Application for a non-material amendment following a grant of planning permission.

<input type="text" value="Erection of 30 bed care home and 4no extra care units (C2) with ancillary parking"/>	
Reference number:	<input type="text" value="APPLICATION NUMBER: 18/02037/FUL"/>
Date of decision	<input type="text" value="17/05/2019"/>

Amendments to increase the head heights of all windows and moving art stone band in line with this. Window transom heights also amended to avoid visual intrusion for occupants in line with Equality Act Guidance

DRAWING TITLE: PROPOSED ELEVATIONS

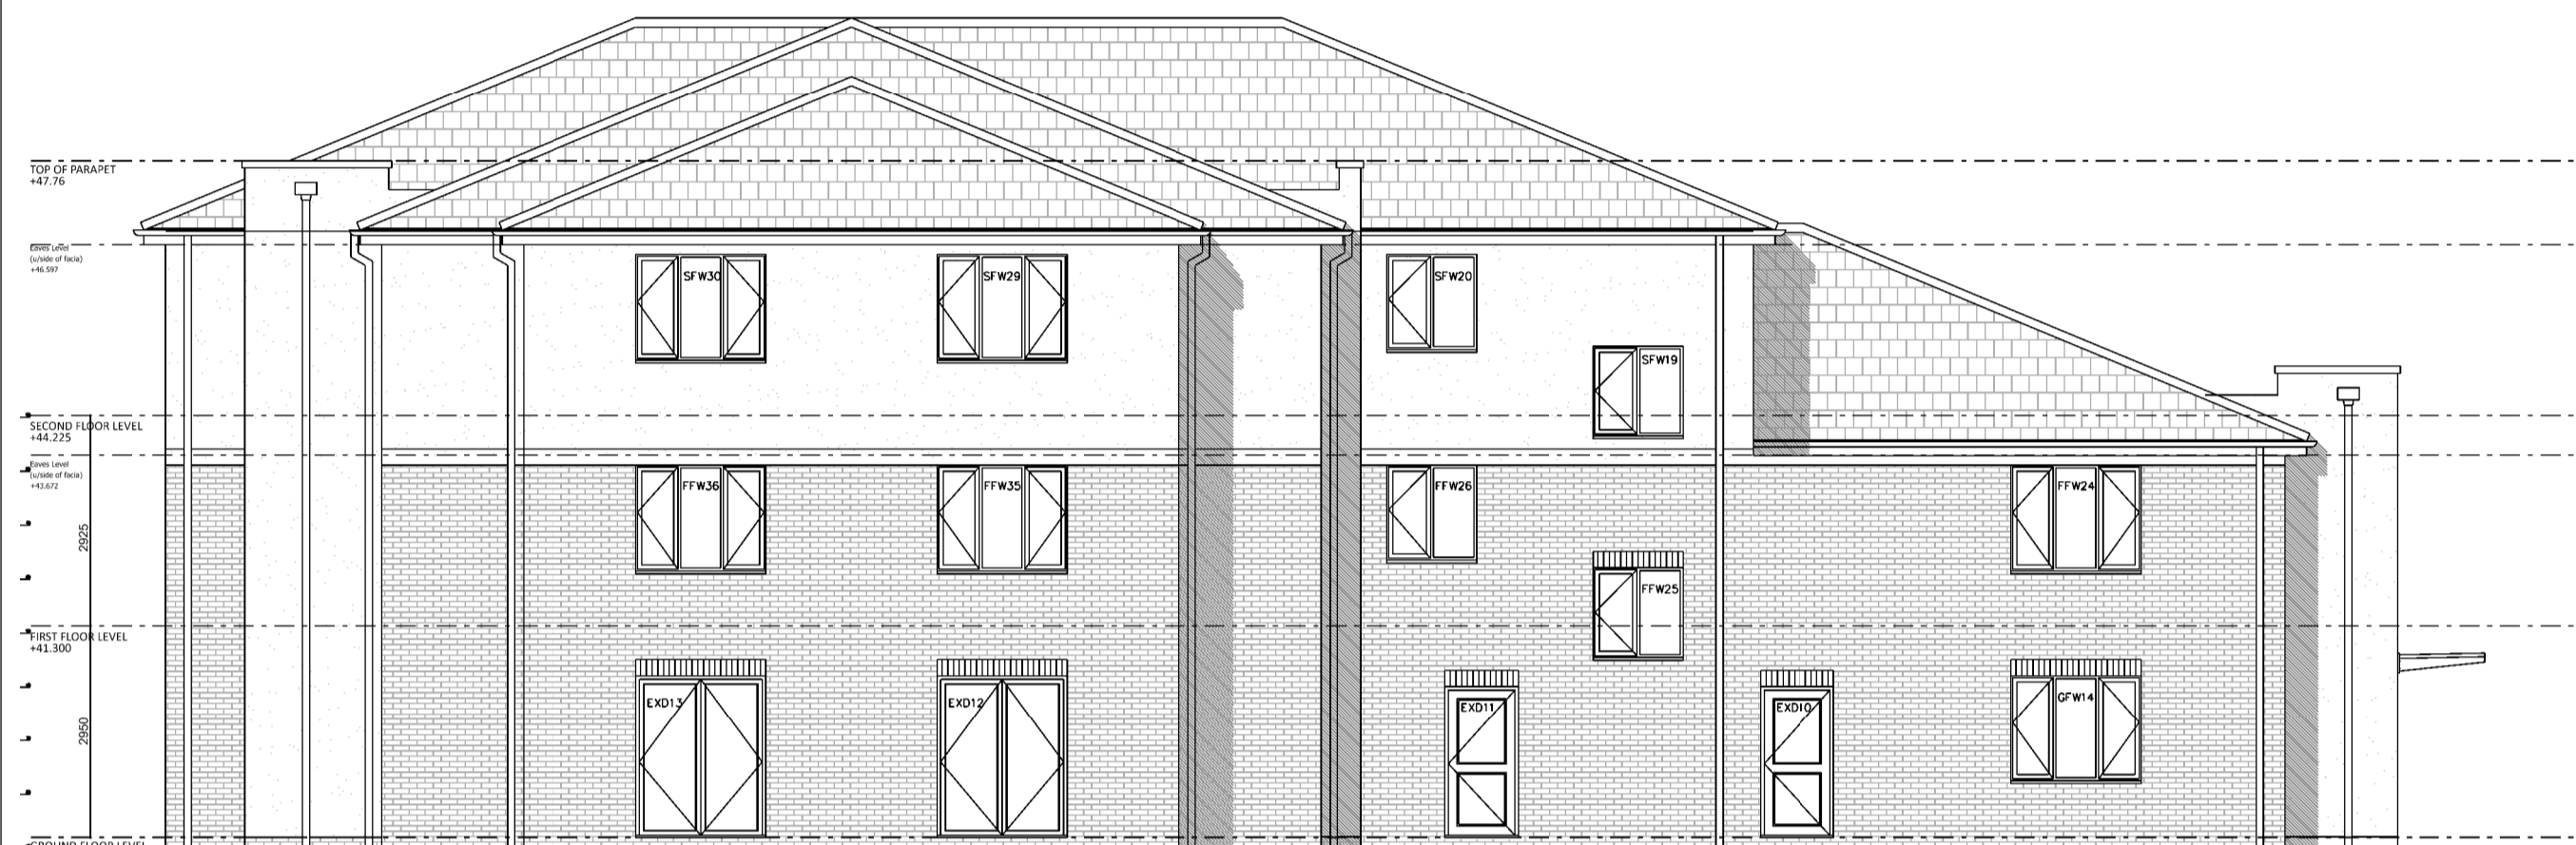
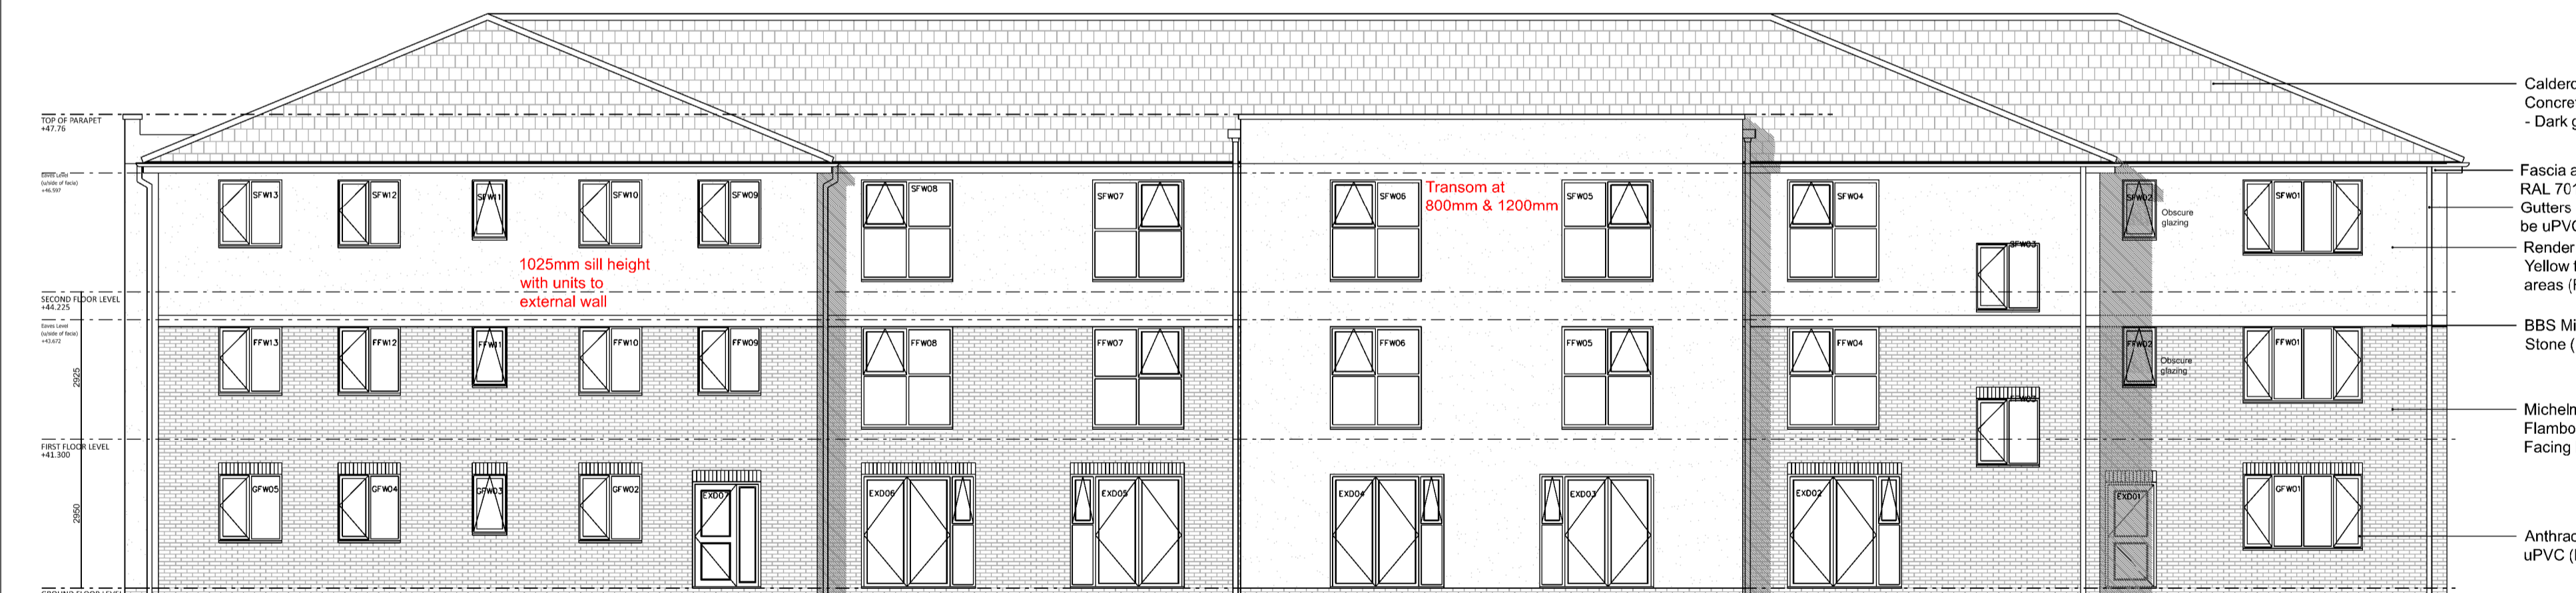
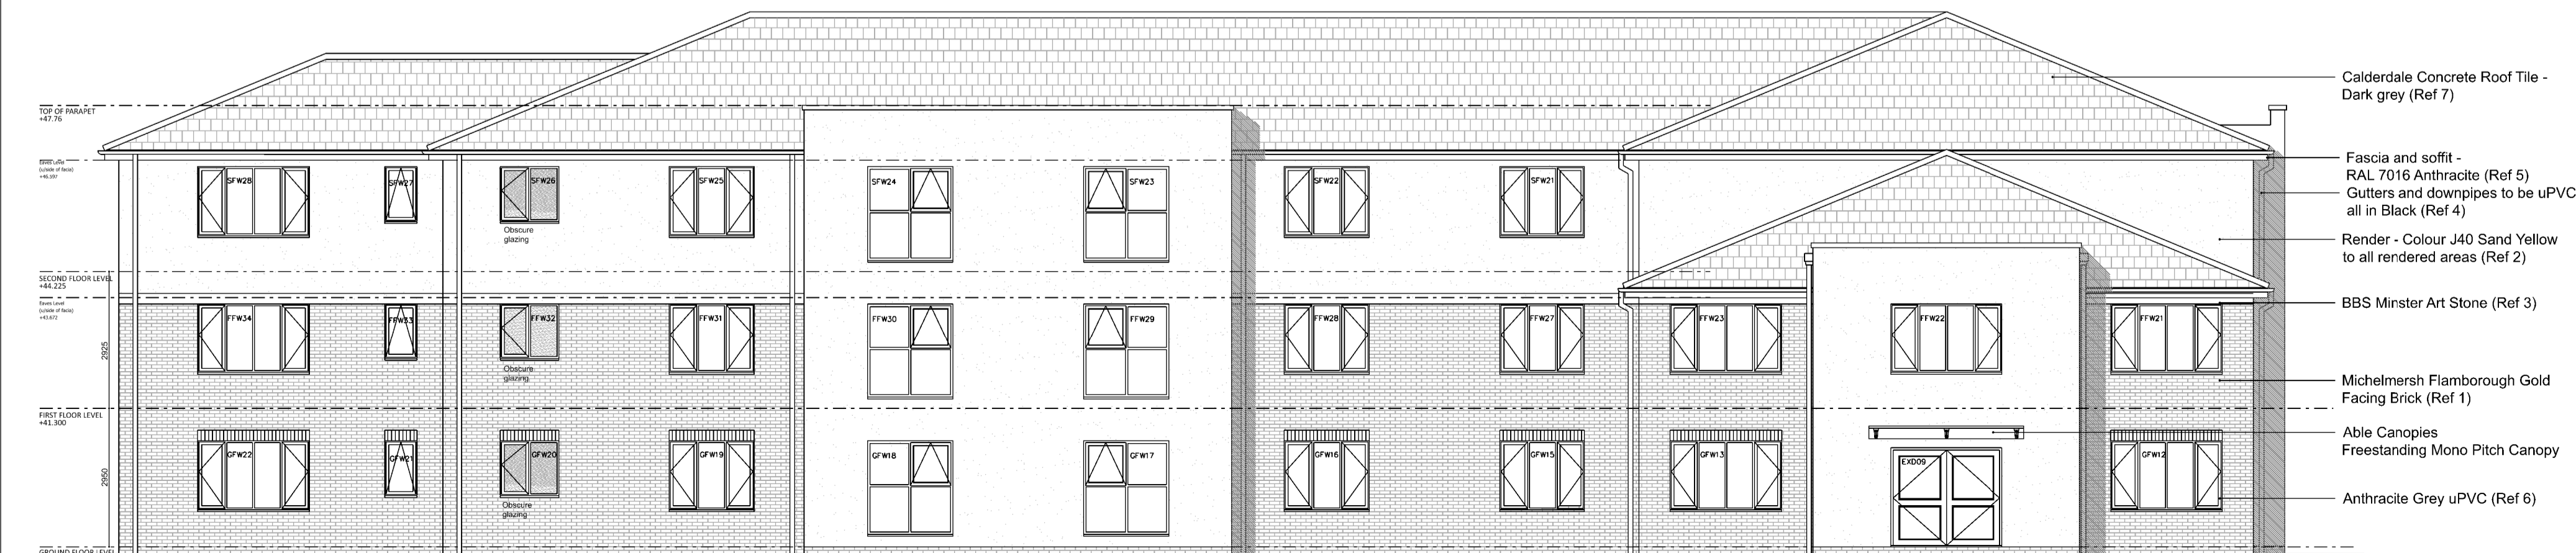
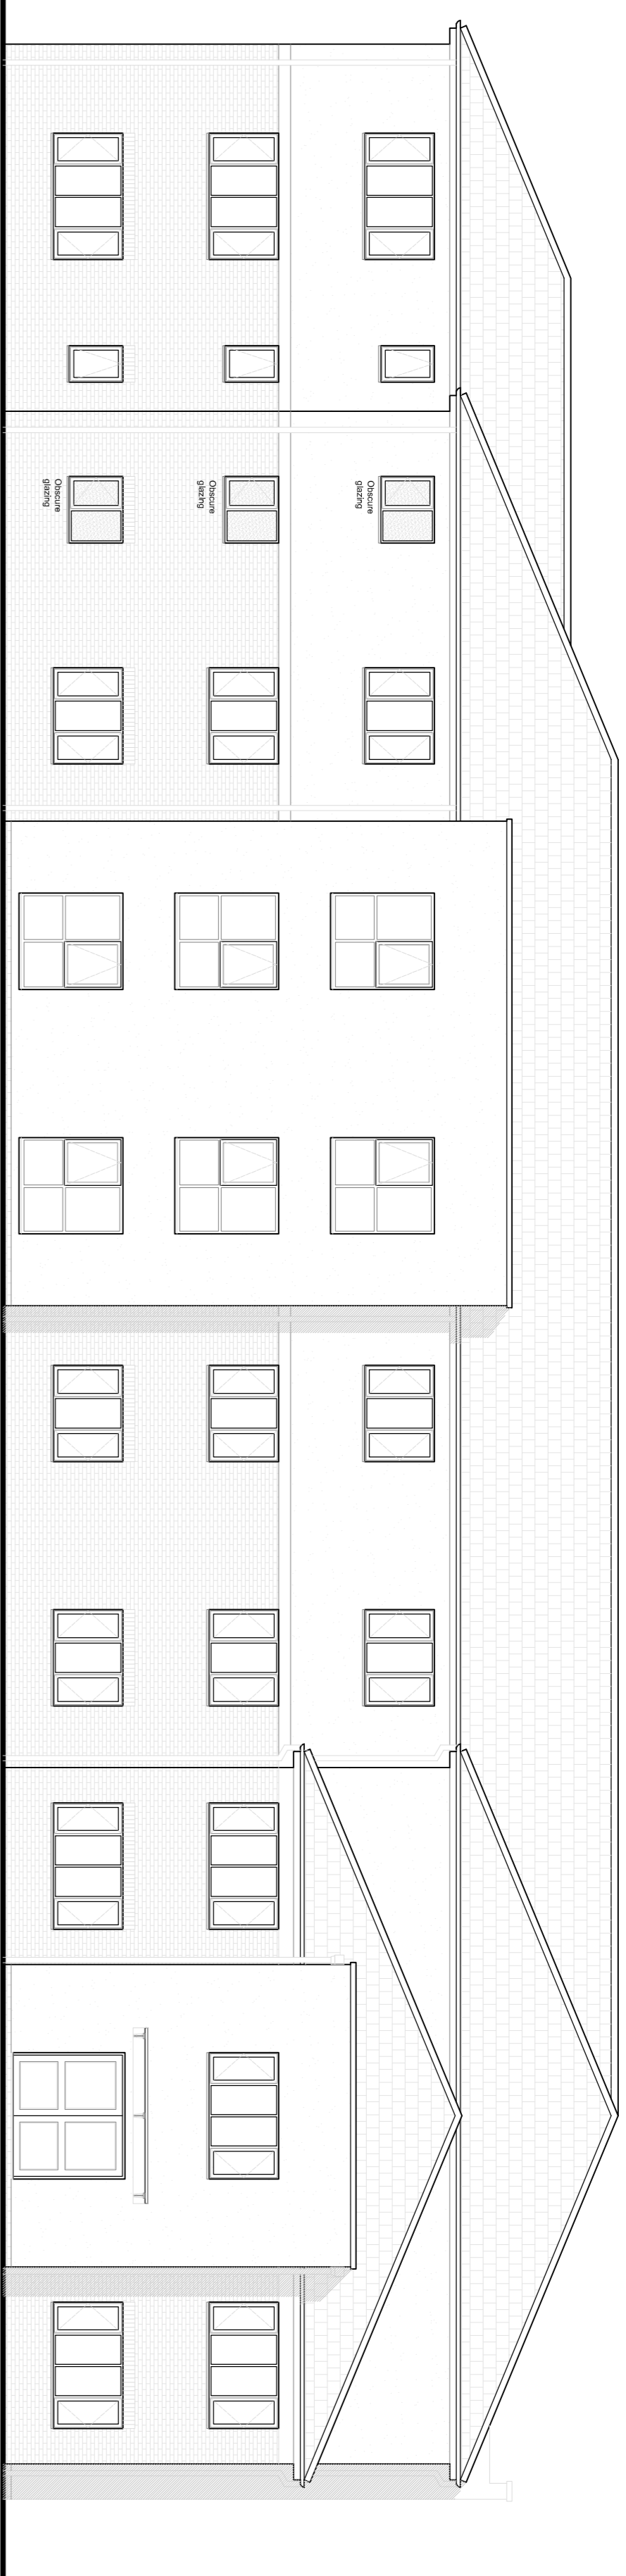
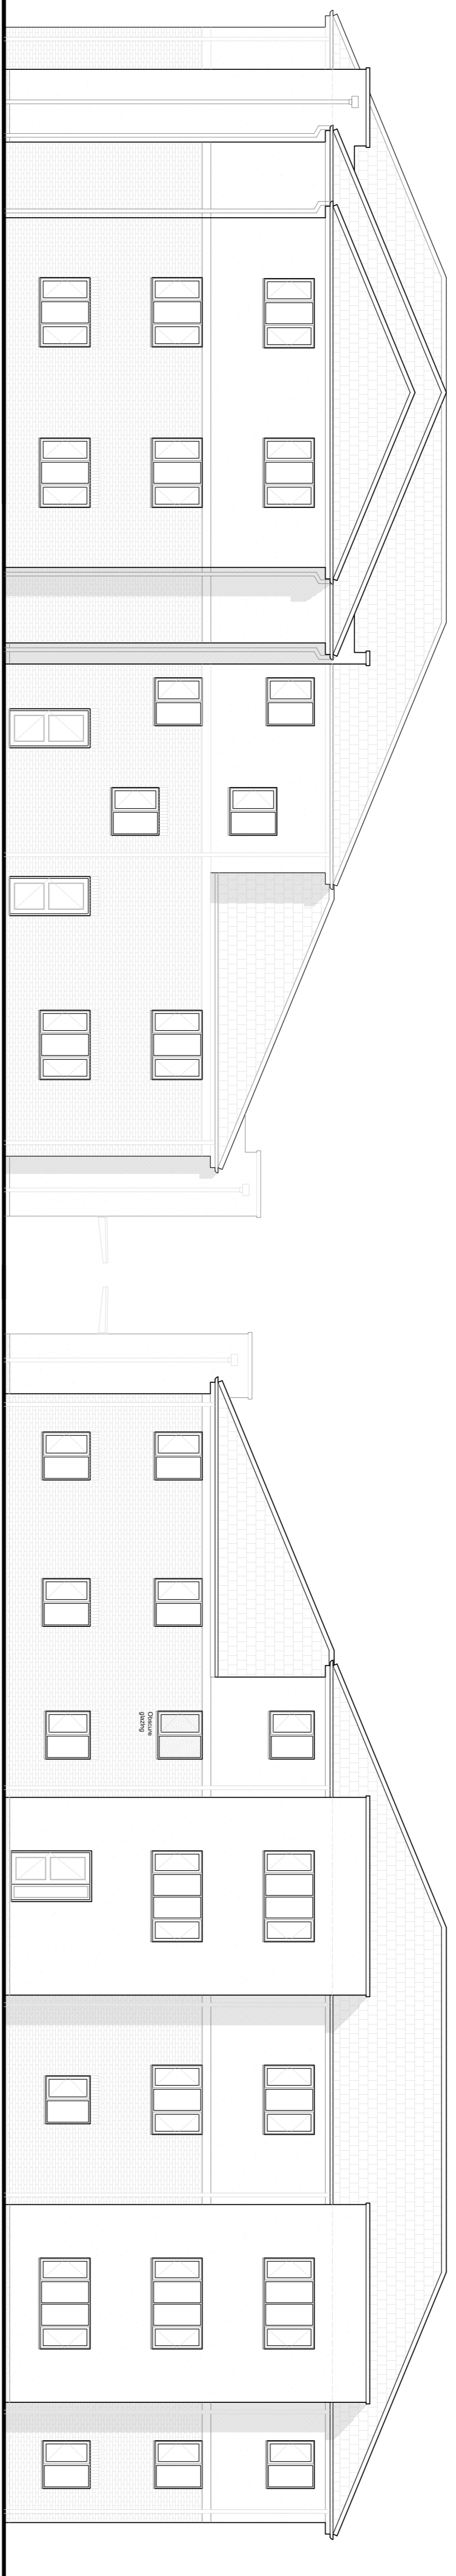
Increase levels of natural light within the building, which is beneficial for the residents. Window transom heights amended to avoid visual intrusion for occupants in line with Equality Act Guidance

S+SA_6498_SK103 A_ Proposed Elevations
